District: Cherwell

Application No: 19/02804/DISC

Proposal: Discharge of Condition 5 (specification details of vehicular accesses, driveway and turning areas) of 19/00441/REM

Location: Phase 5C Parcel D2E, Camp Road, Upper Heyford

1. For use on vehicular crossovers from/ to blacktop highways.  
**ADOPTABLE VEHICULAR CROSSING DETAIL**

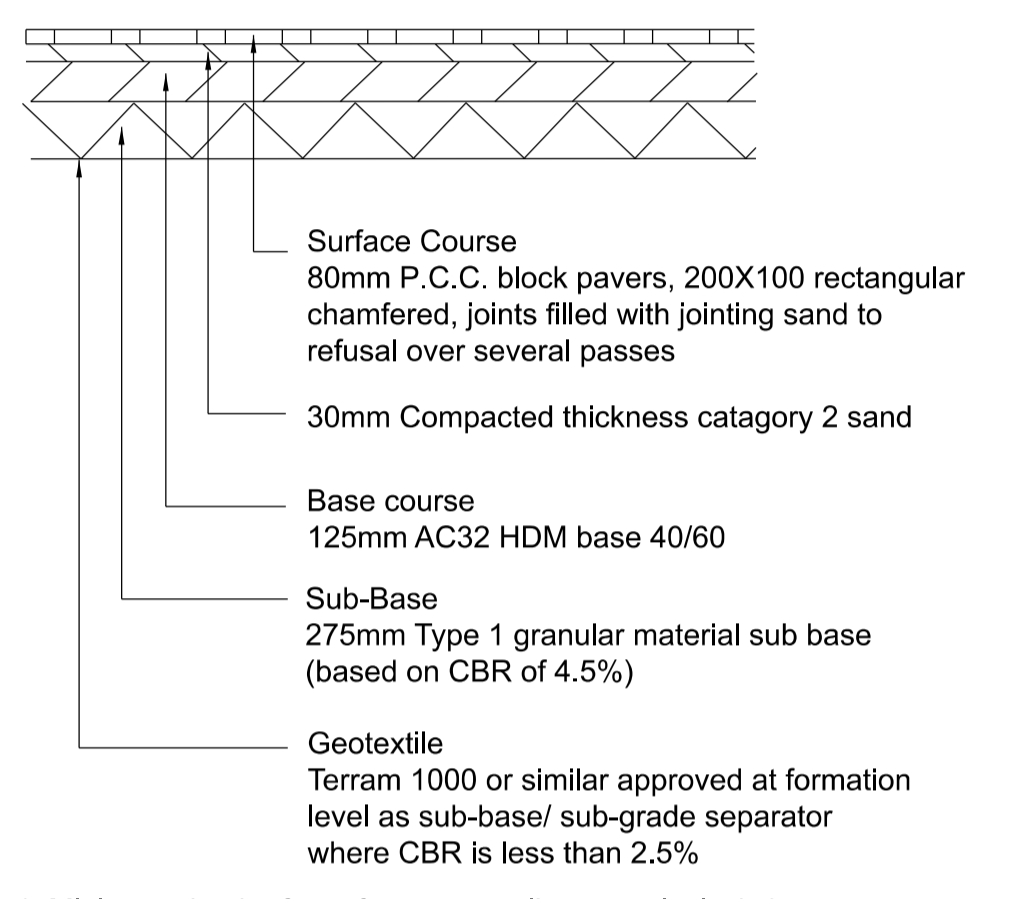
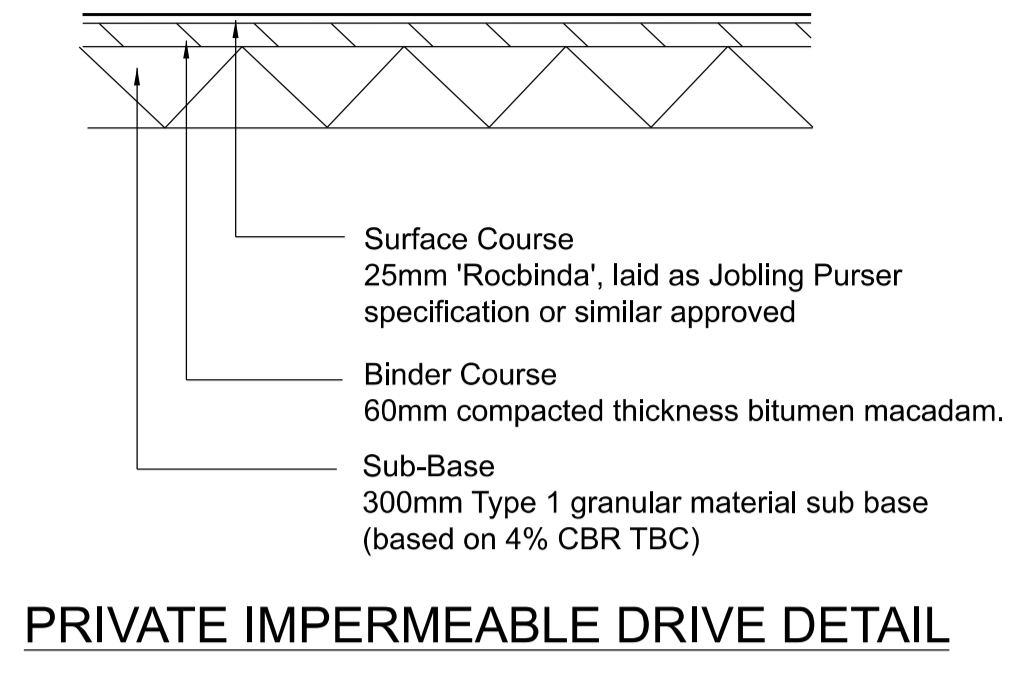
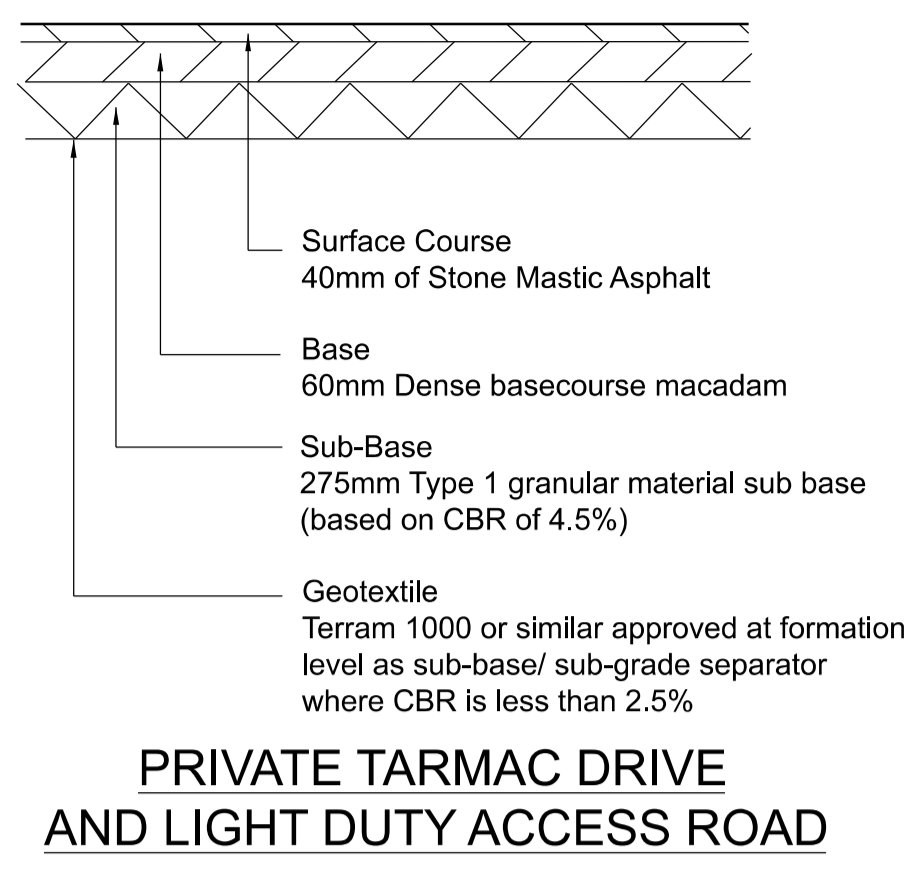
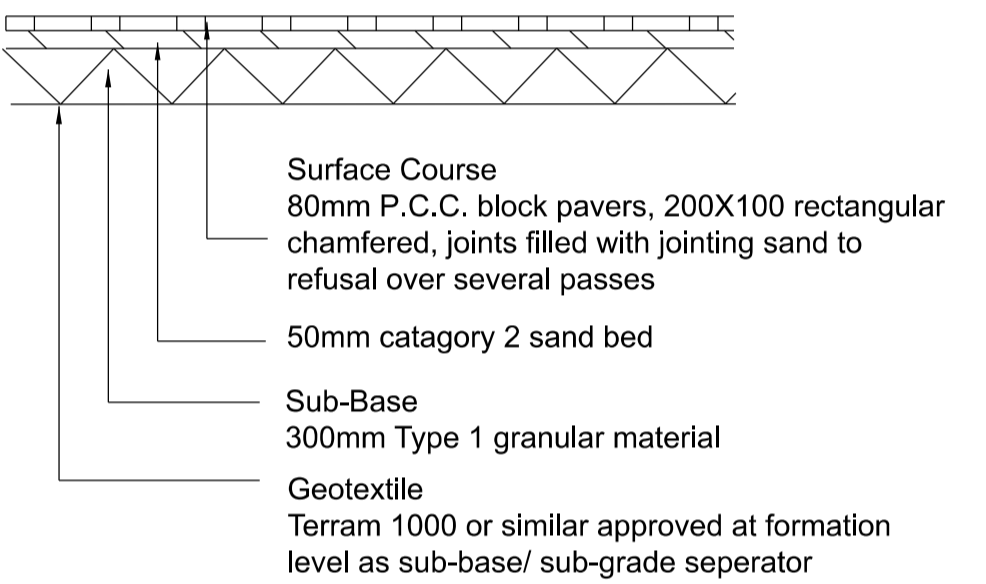
All car parking spaces are accessed directly from adjacent roads and there are no internal driveways and turning areas. Construction details are acceptable in principle, and the Section 278 works for this phase are already partially completed.
